**NON-MATERIAL AMENDMENT APPLICATION FOR PROPOSED REDEVELOPMENT OF THE
LITTLEHAMPTON LEISURE CENTRE SITE AT SEA ROAD, LITTLEHAMPTON, WEST SUSSEX,
BN16 2NA**

Enclosed herewith, please find a Non-Material Amendment application in respect of planning permission ref. LU/314/16/PL granted January 2017, relating to the Littlehampton Leisure Centre site at Sea Road, Littlehampton, West Sussex, BN16 2NA.

DESCRIPTION:
SITE PLAN : PROPOSED INCOMING SERVICES

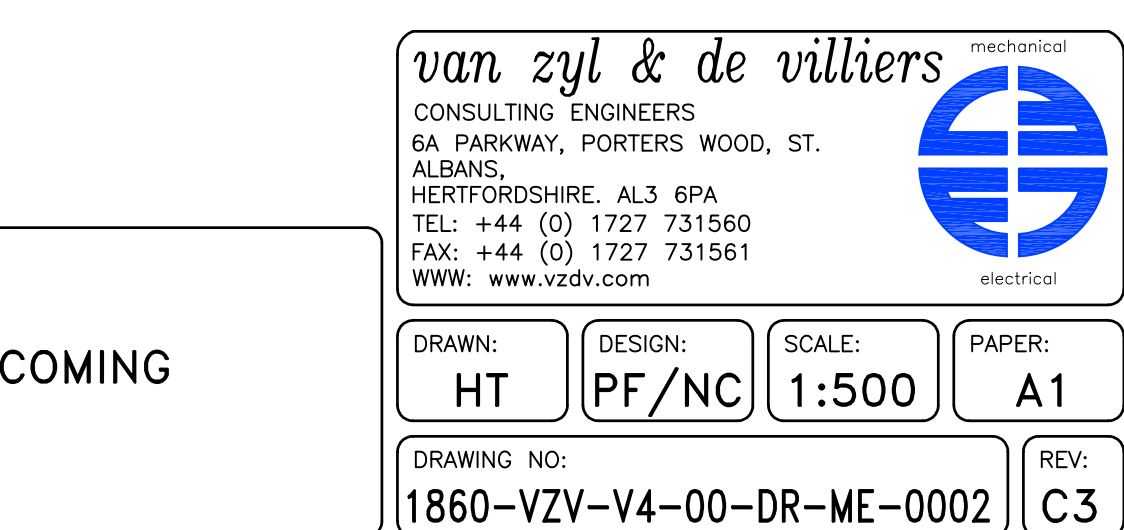
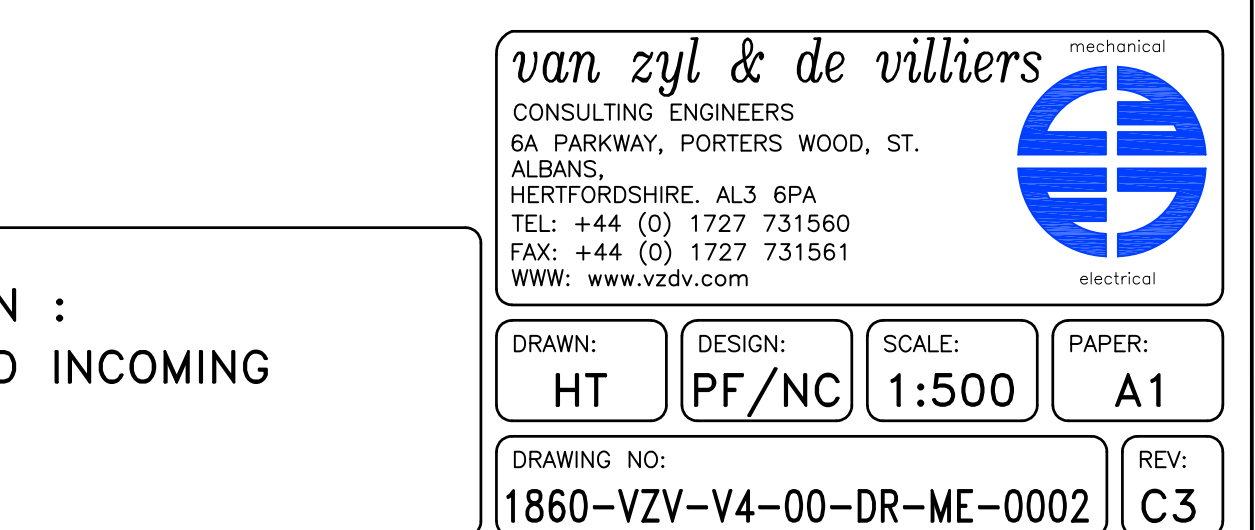
- Amendment of the gas meter location, from the west of the building (in the service yard) to the Sea Road boundary, east of the existing site entrance in the grass verge.
